EROSION AND STORMWATER QUALITY CONTROL PERMIT (ESQCP) EL PASO COUNTY APPLICATION AND PERMIT

EPC Project Number: 236

EARLY GRADING & EROSION CONTROL PLANS
GEC INITIAL

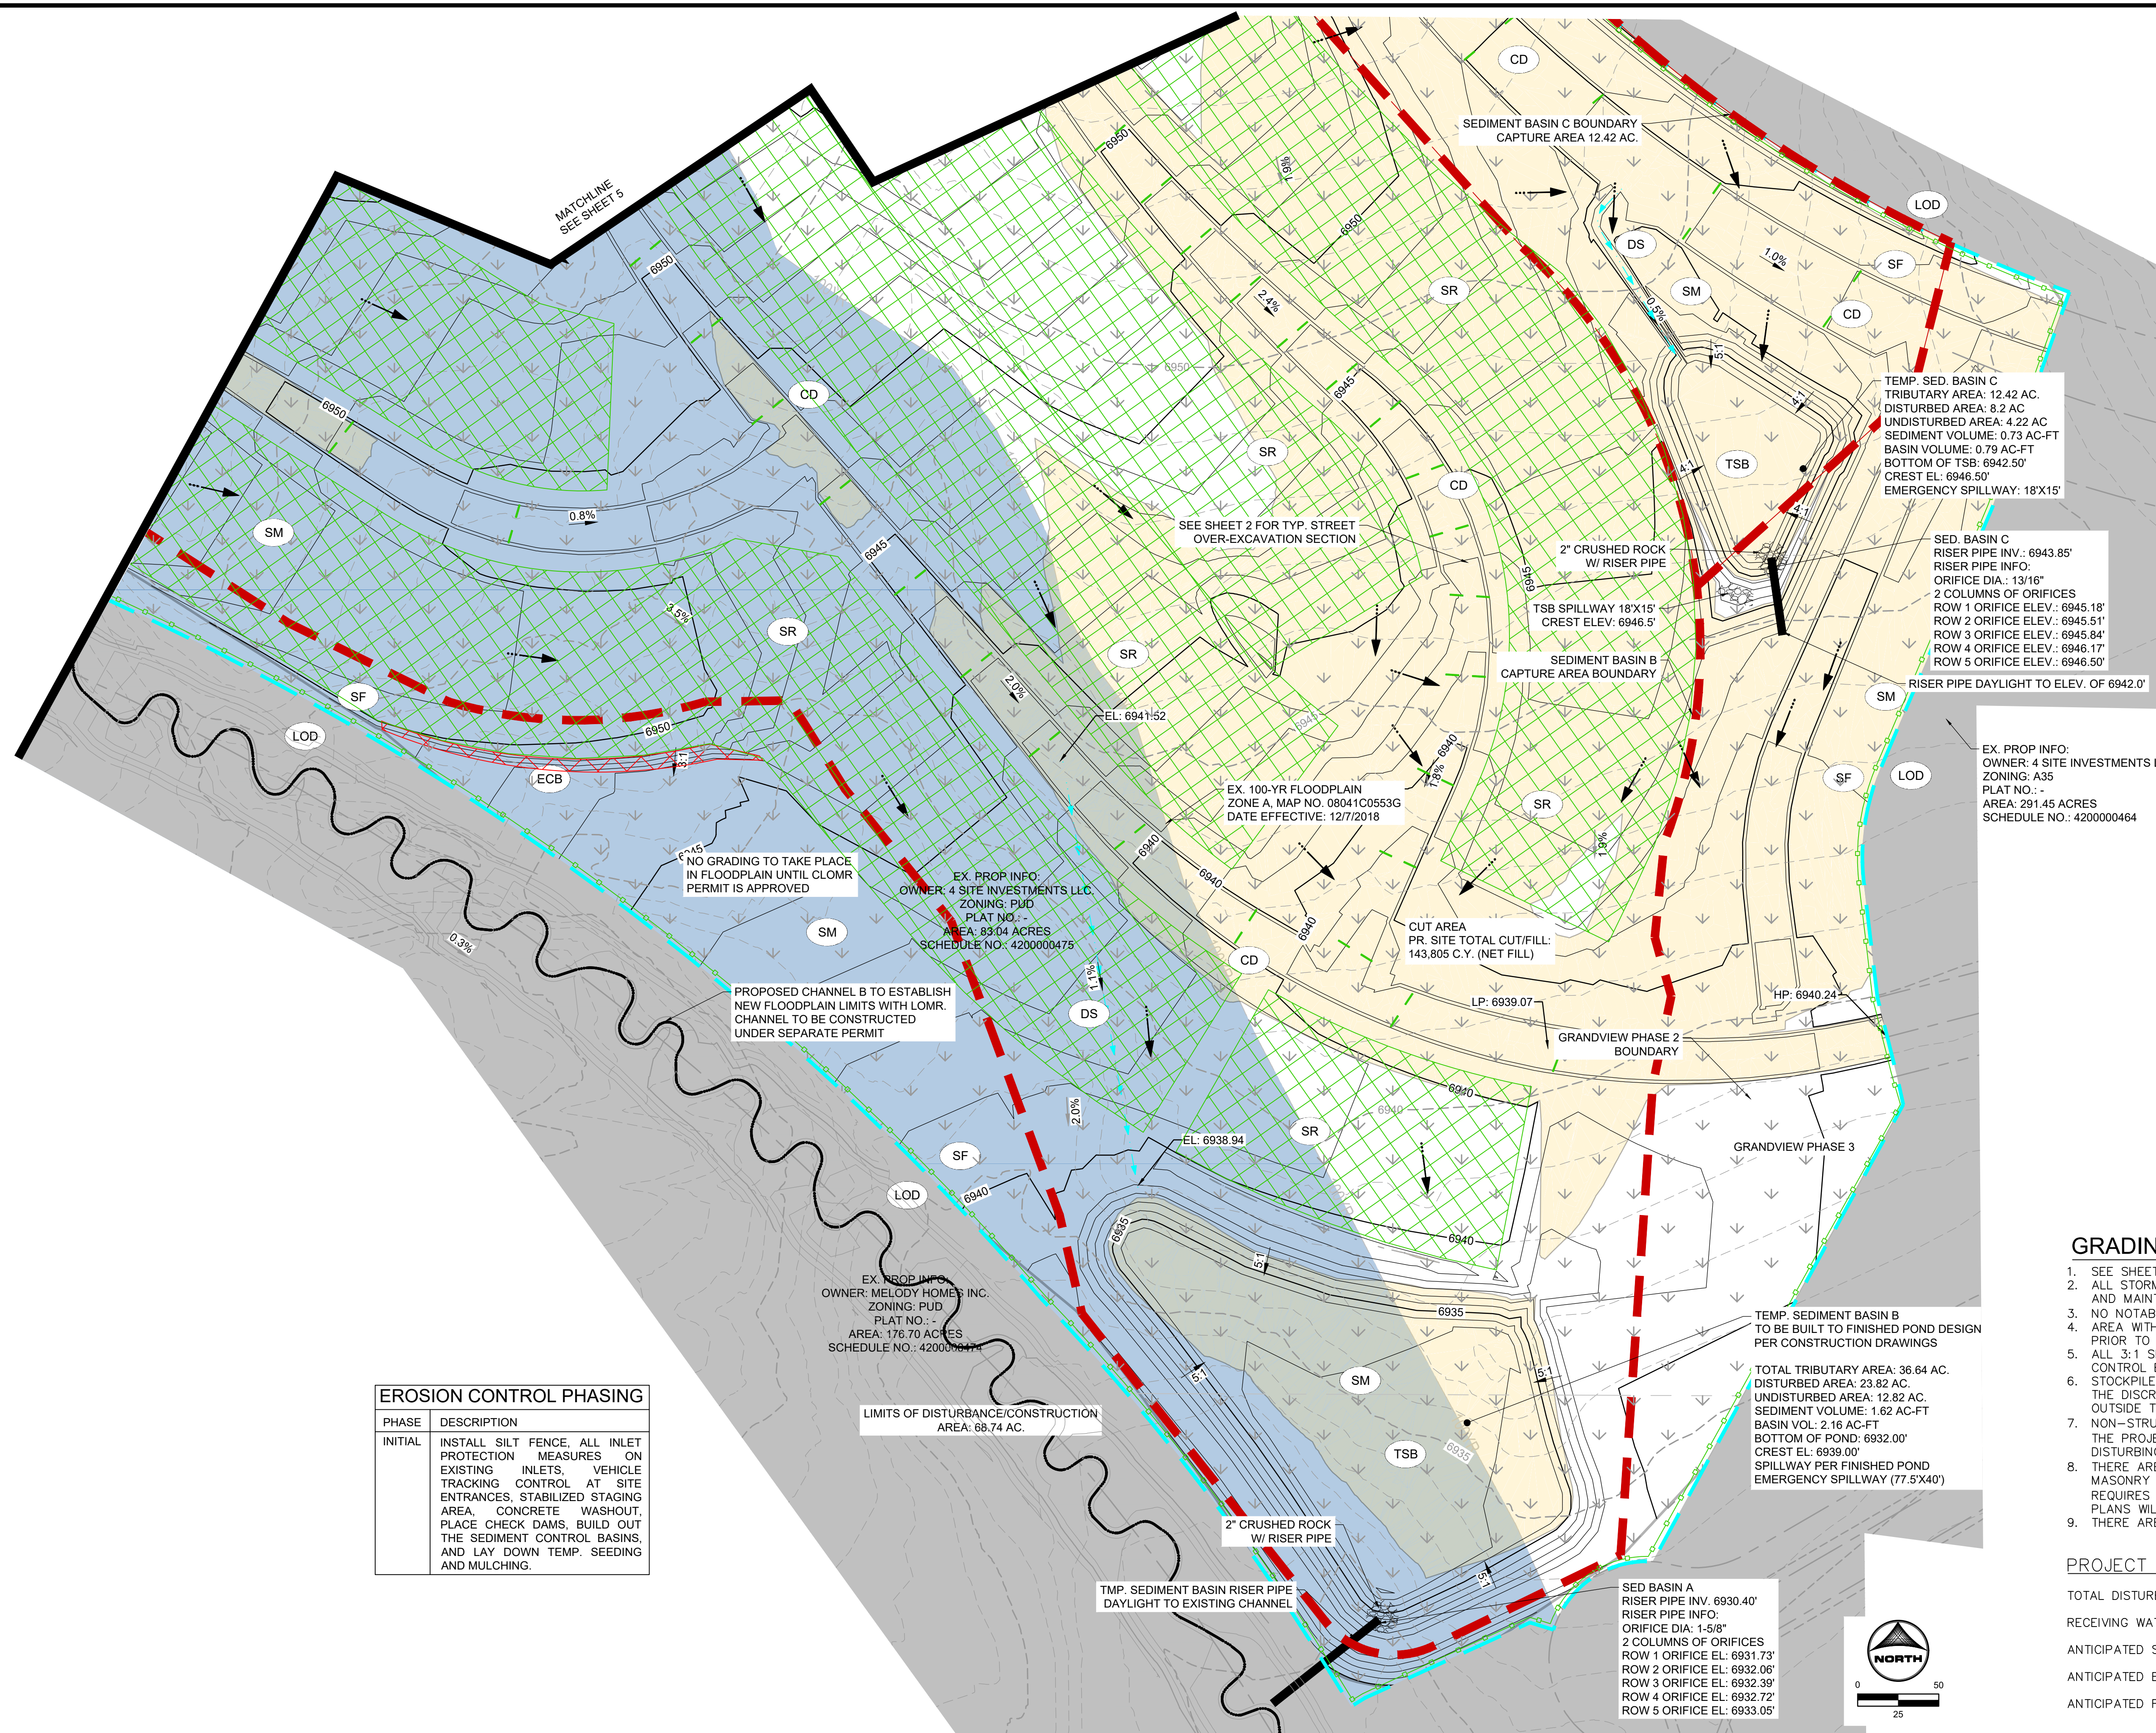
Project Information	
Project Name	
Legal Description	
Address (or nearest major cross streets)	
Acreage (total and disturbed)	Total: _____ acres Disturbed: _____ acres <div style="border: 1px solid orange; padding: 2px; display: inline-block; margin-top: 5px;">The SWMP text states that both of these values are 70.7ac</div>
Schedule	Start of Construction: Completion of Construction: Final Stabilization:
Project Purpose	
Description of Project	
Tax Schedule Number

I know that this is approximate but the GEC Plan shows 68.28. At least make them consistent to avoid any confusion.
